## Application for a Non-Material Amendment Following a Grant of Planning Permission

Erection of detached dwelling with integral garages and new access

20/0777/FUL

Dwelling Moved Further South

63004/PE/REVB

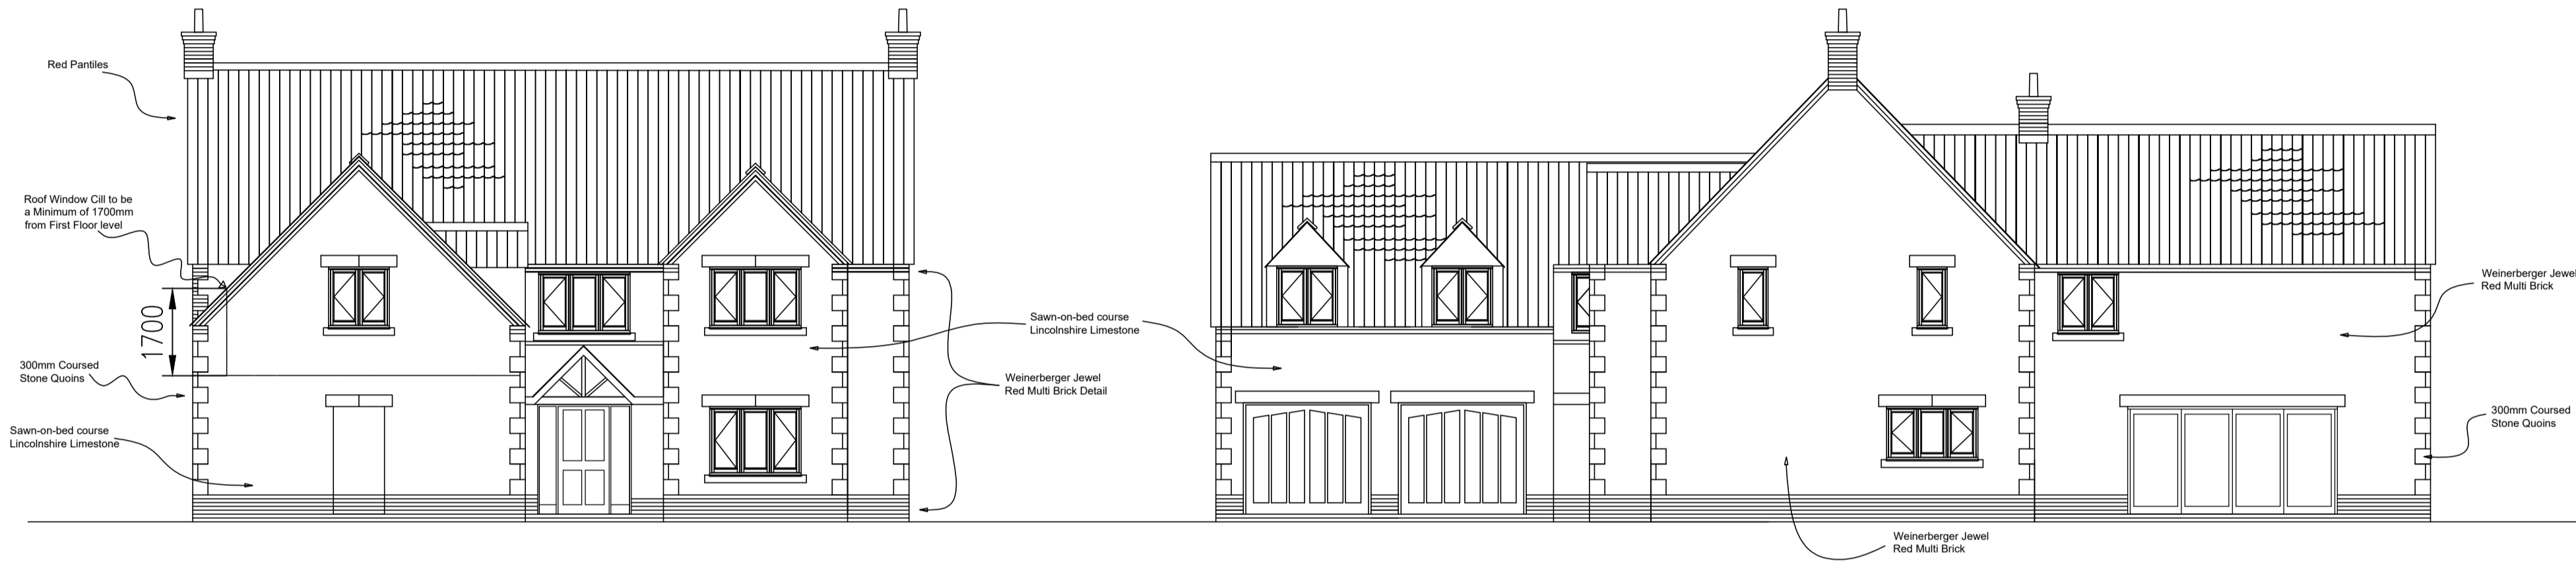
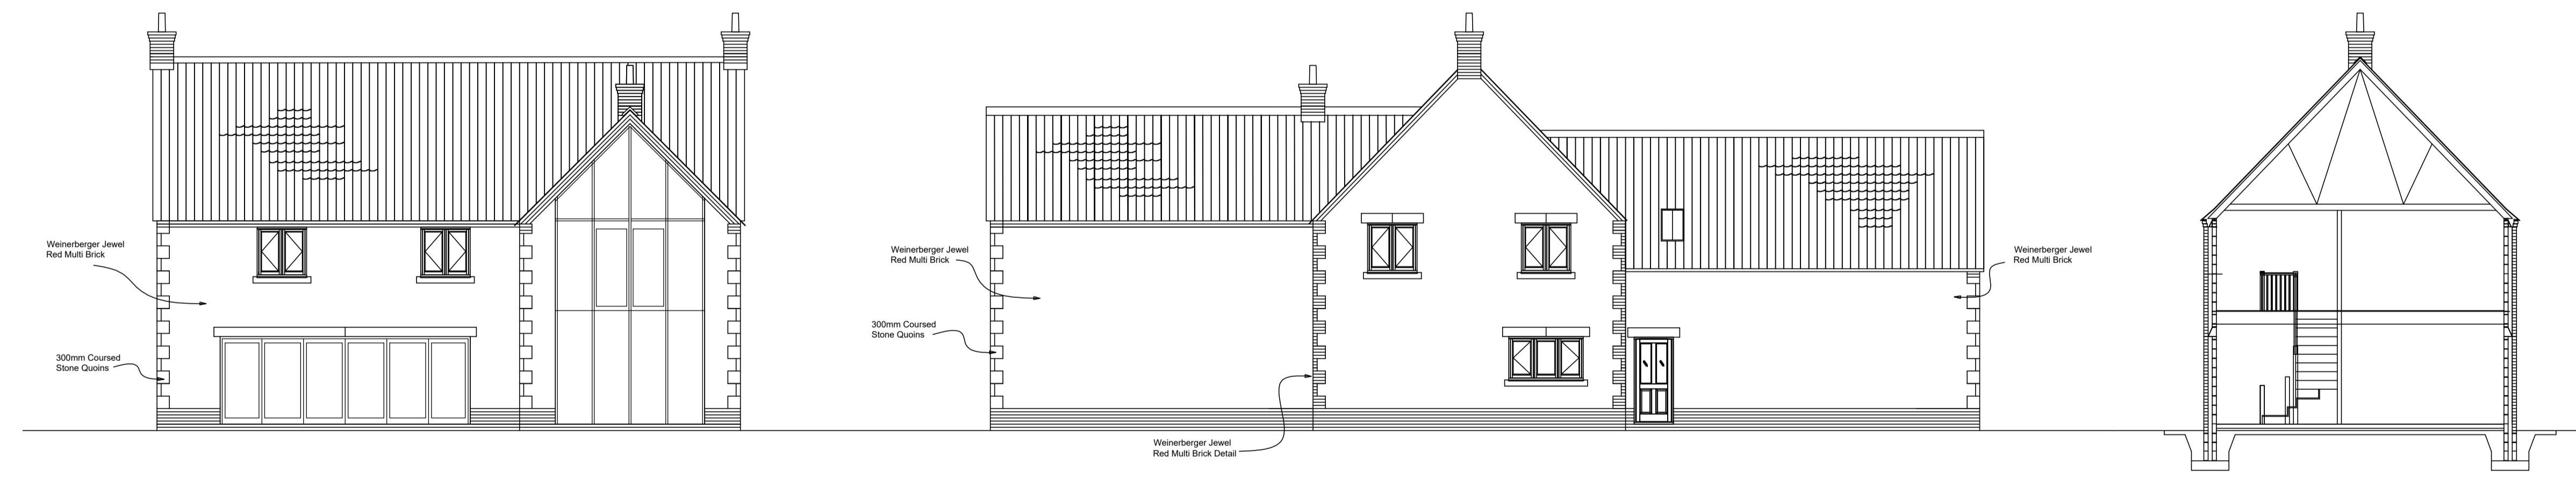
Added Solar PV Panels on West, East & South Elevations

300mm Stone Band added to the entire house

Change Roof Material from Red Pantiles to Slate-Style Concrete tiles

300mm Stone Band added to the entire house: Common design feature seen throughout Sawn-on-bed Limestone houses in Scopwick and other surrounding villages

Stone / Brickwork Layout: Mixed Coursed Sawn-on-bed Limestone and brickwork throughout house, to further match properties within Scopwick, shown on drawing 63004/PE/REVC.

Change Roof Material from Red Pantiles to Slate-Style Concrete tiles: To further match properties within Scopwick including The existing Limes Care Home, shown on drawing 63004/PE/REVC

Date	April 2024	Drawing Number
Scale	1:50 @ A1	
Drawn	A.P.	<b>63005/PFF/REVC</b>

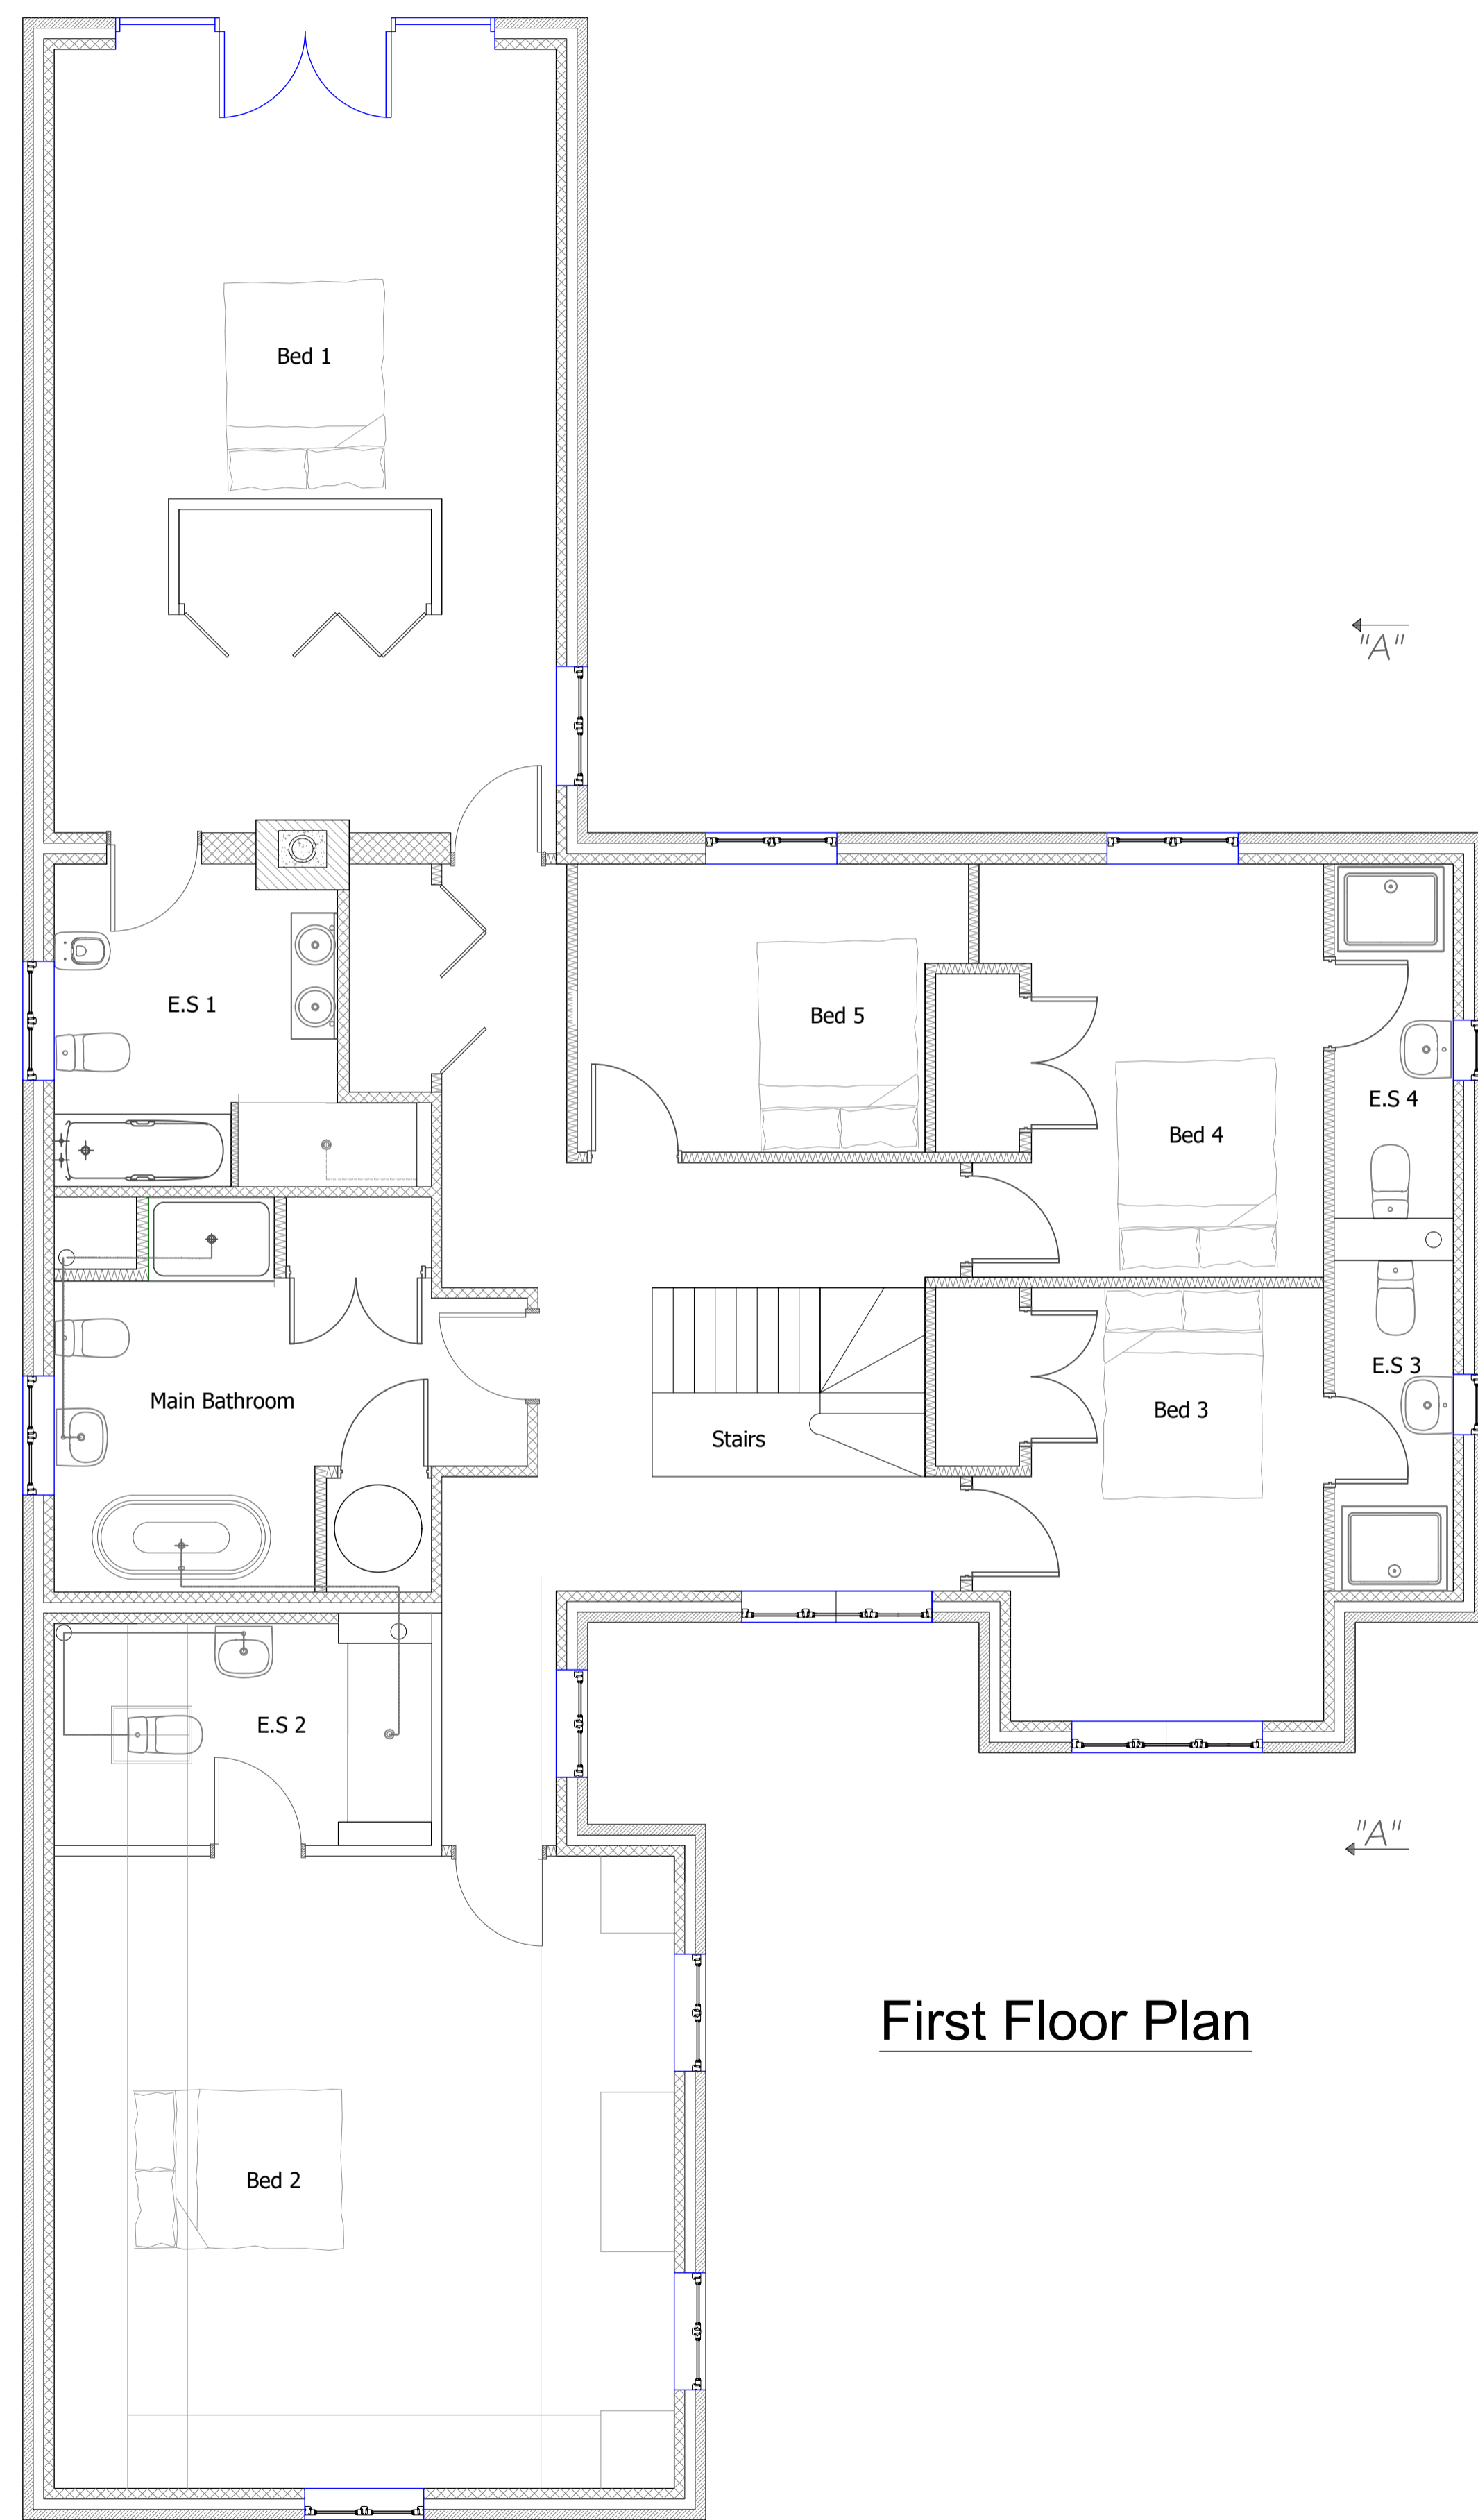
Small Size alteration to Dwelling

Window added to Downstairs WC

Small size only changes to Windows & Glass Screen: Items altered only in sizing to help reduce development costs and work brickwork coursing more efficiently.

Window added to Downstairs WC: Window added for better ventilation

Small Size alteration to Dwelling: No large change in development size, however new sizing works brickwork coursing more efficiently.
